## **South Staffordshire District Council Deadline 1 Submission - TR050005**

In response to the Rule 8 letter dated 4th March I enclose, on behalf of South Staffordshire Council, a summary of points raised at the hearing in relation to the Examining Authority's questions.

### **Issue Specific Hearing on the Draft Development Consent Order (DC)**

B4 - Proposed Road Bridge, Over Existing Canal (Elevation E4)
(Scale 1:100)

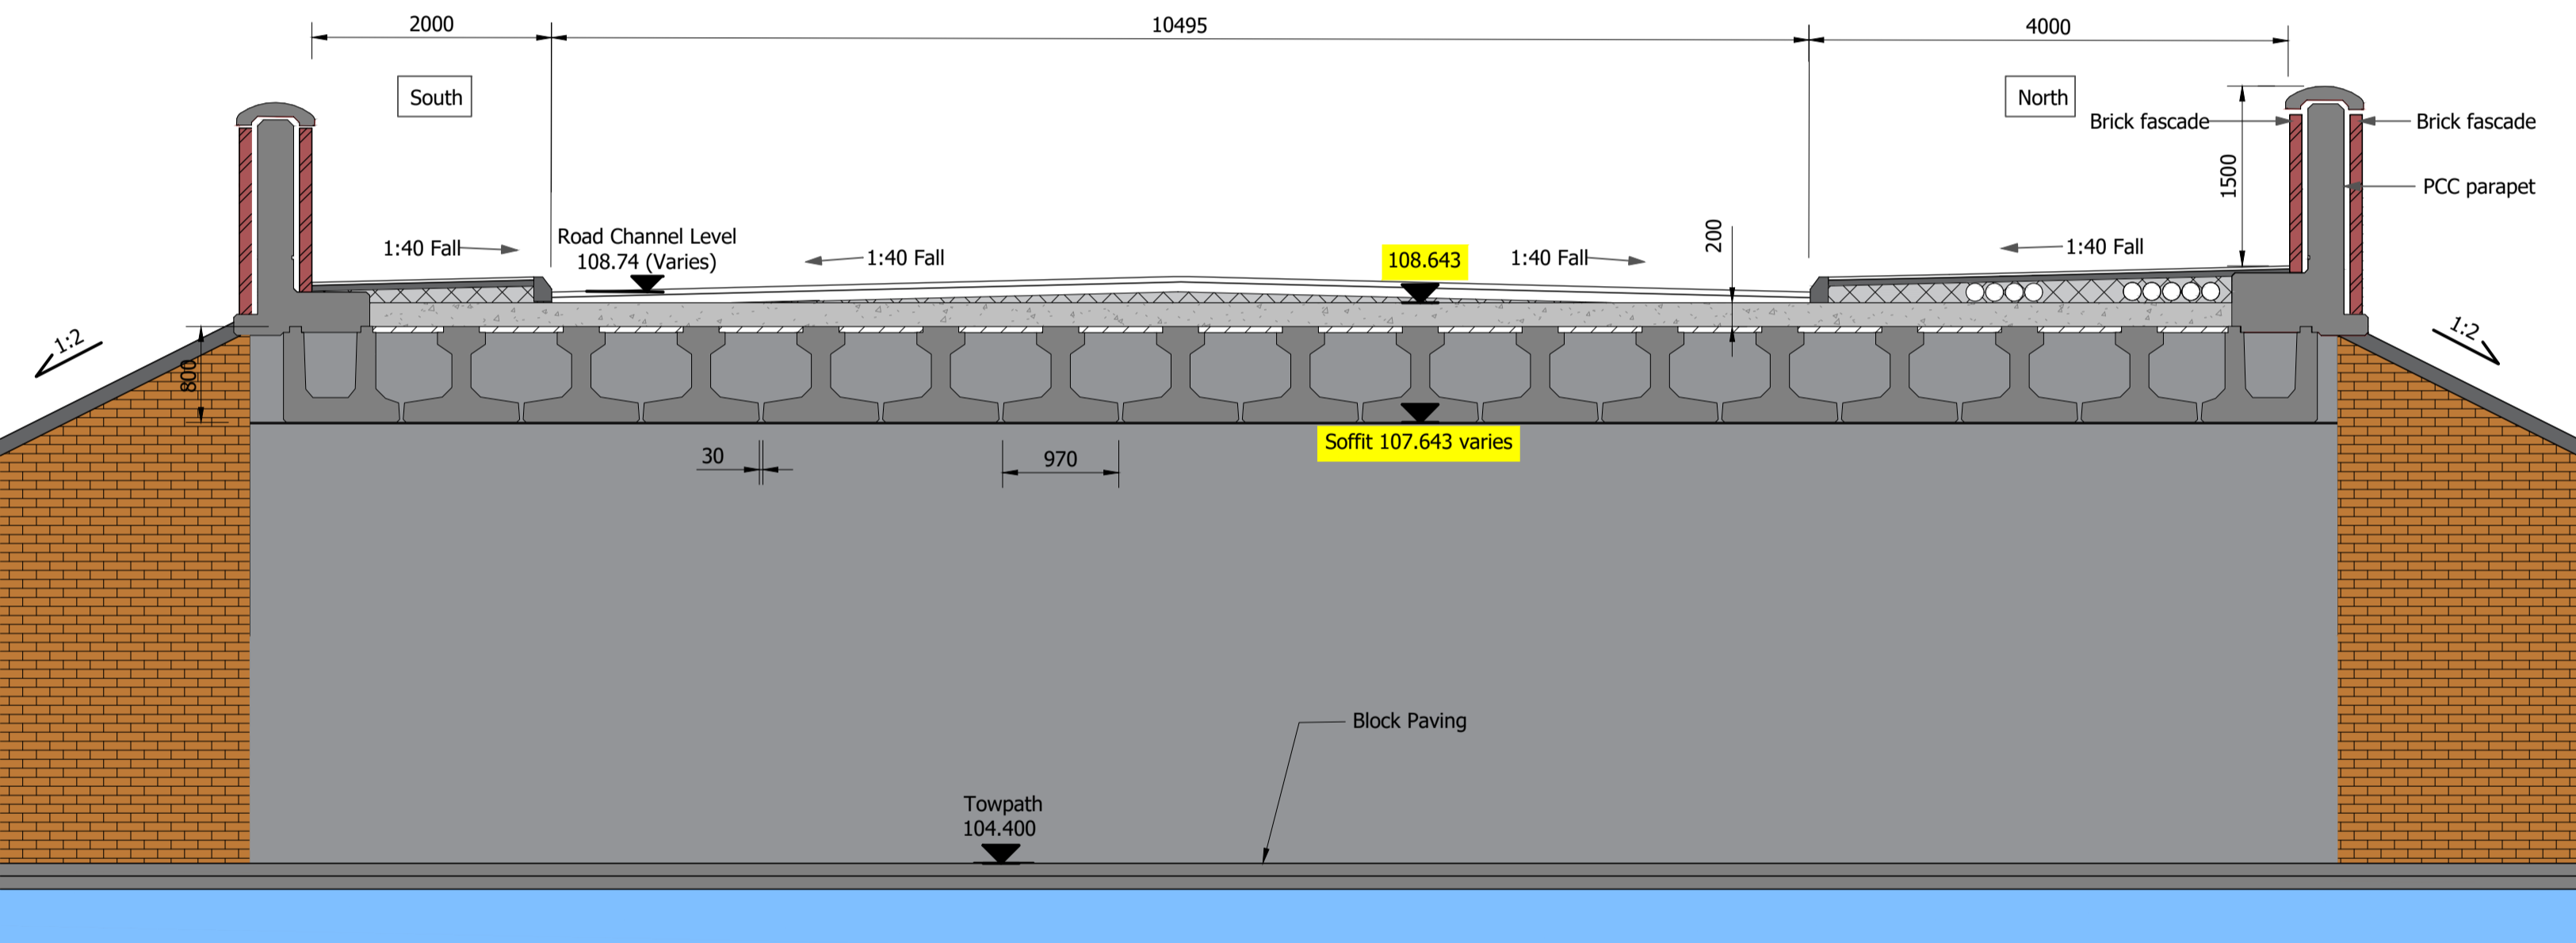
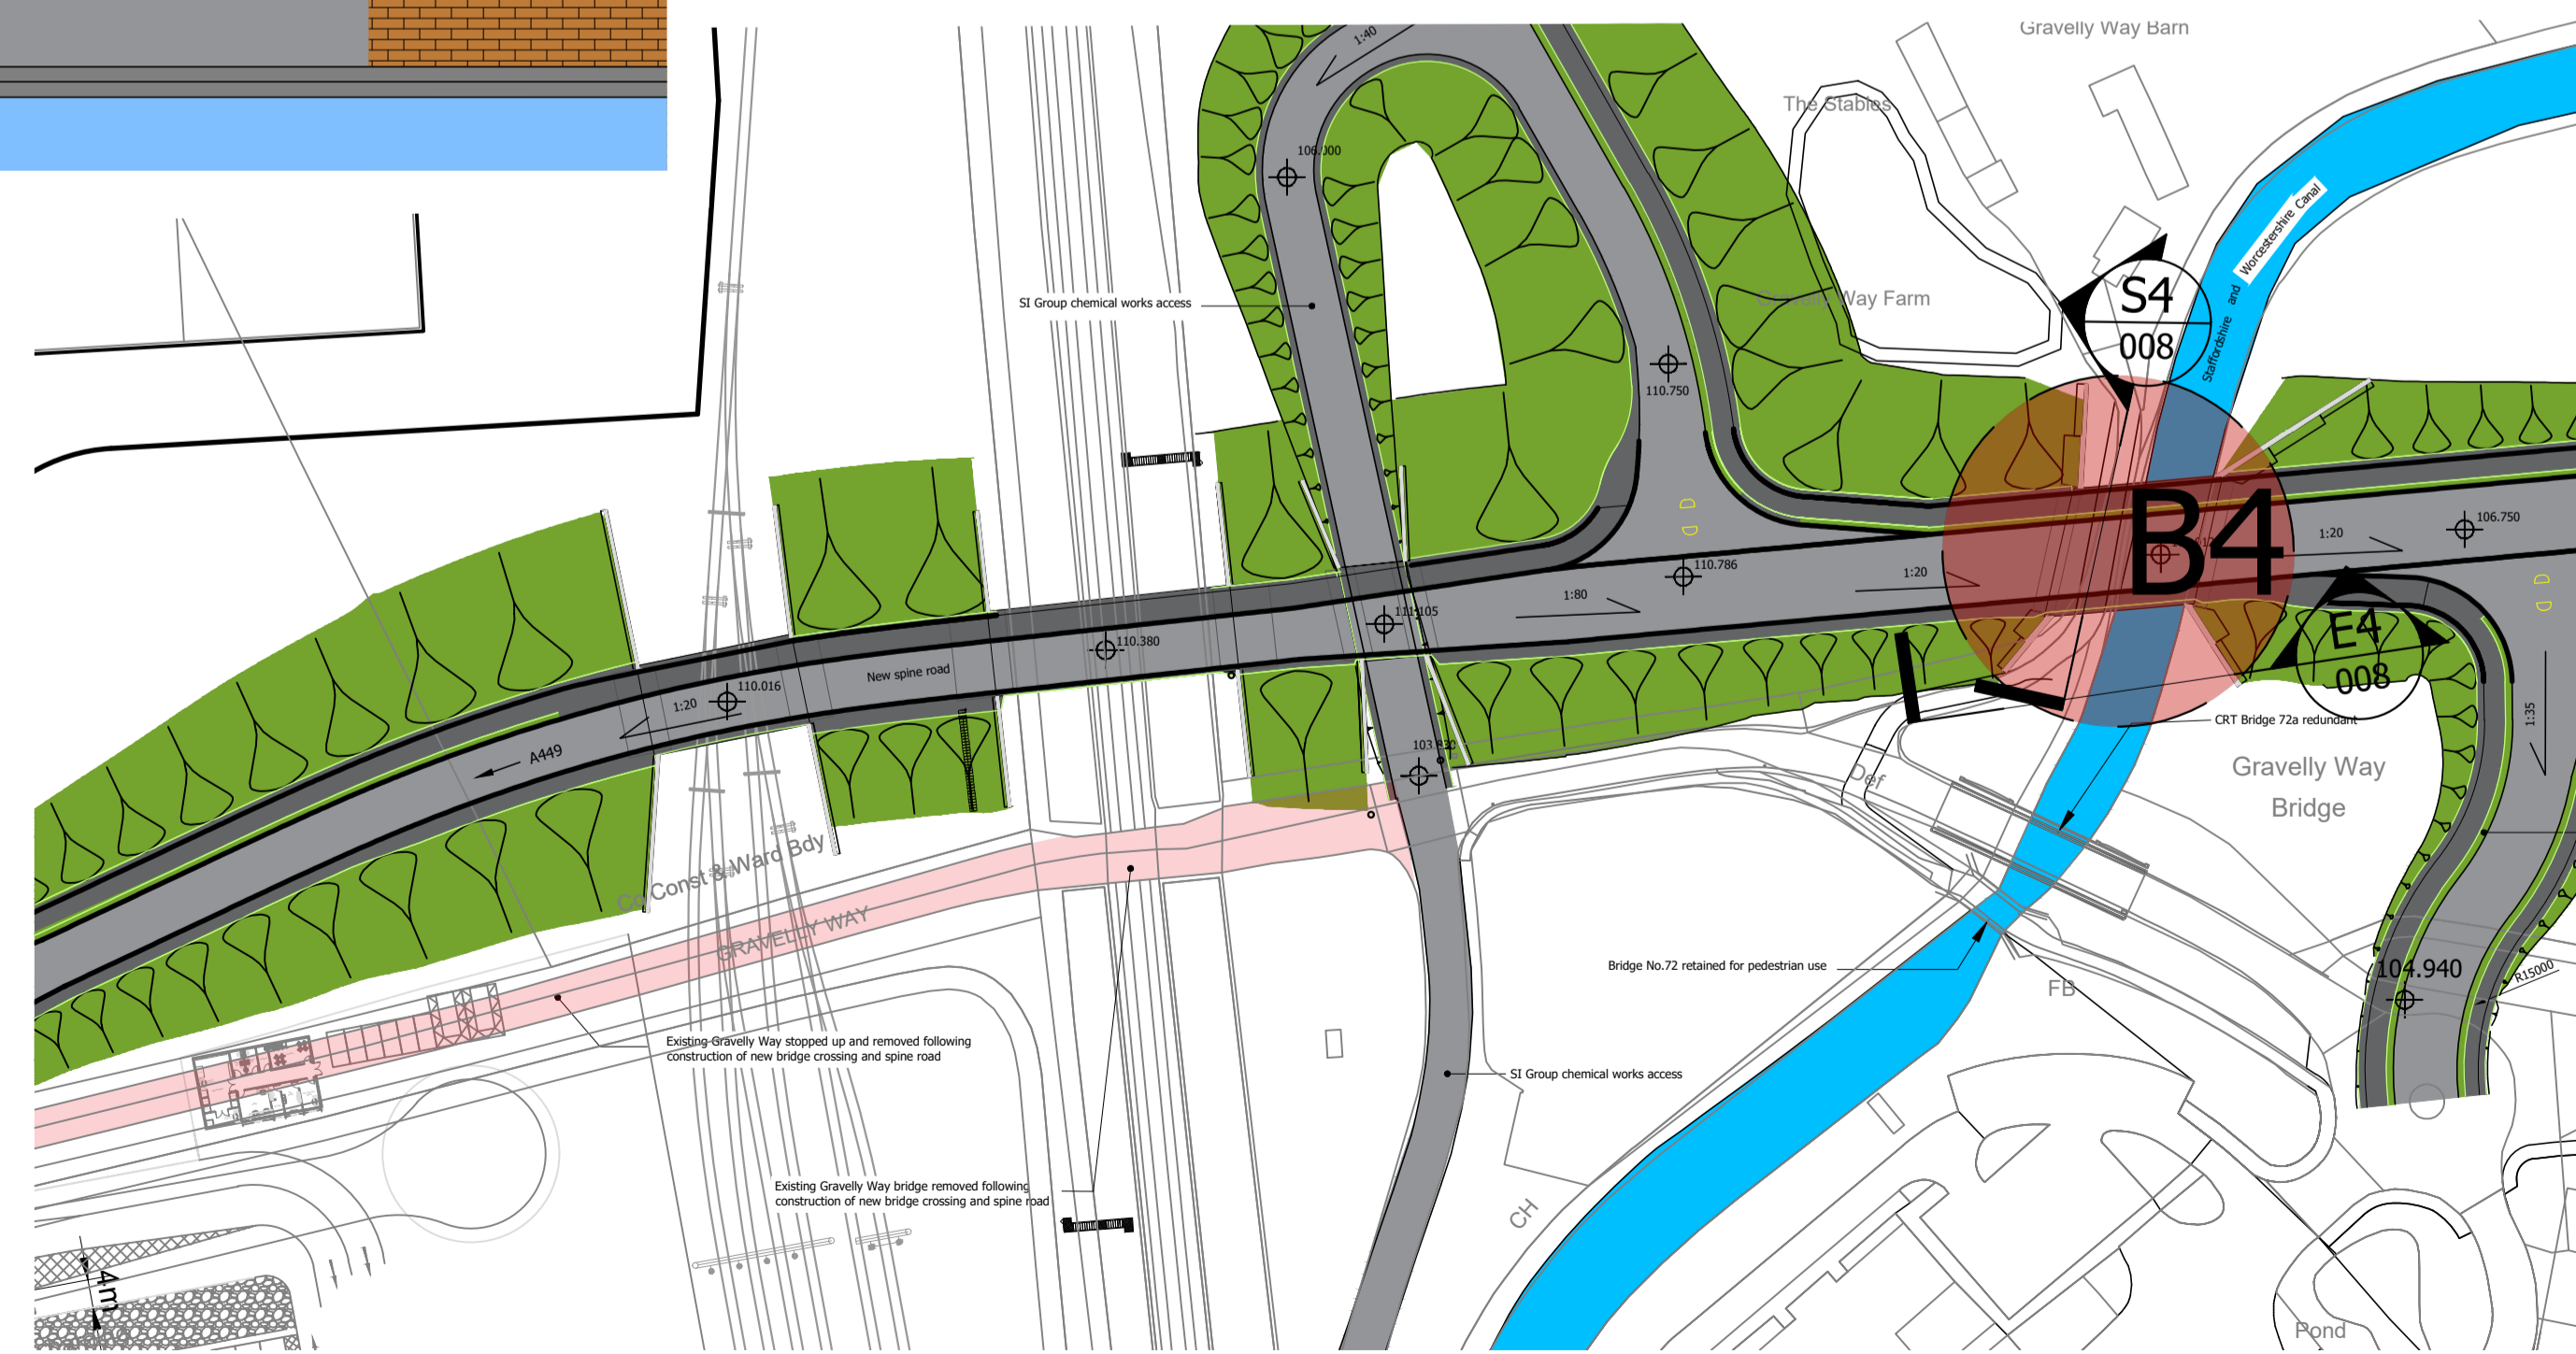
1.10	A4	Applicant	<p>i) How would Clause (b) operate alongside the annotations on the Bridge Plans which indicate detailed levels for the underside, deck and other key elements of the proposed bridges and set minimum clearance levels for the underside of bridges?</p> <p>ii) Would there be a risk that the flexibility provided by Clause (b) might operate in tandem with that provided by Clause (c) (i.e. in relation to a bridge over part of the railway works) to result in an upwards deviation in the level of such a bridge by 3 metres?</p> <p>iii) Has the full degree of flexibility provided for in A4 been assessed in the ES on a worst case basis?</p>
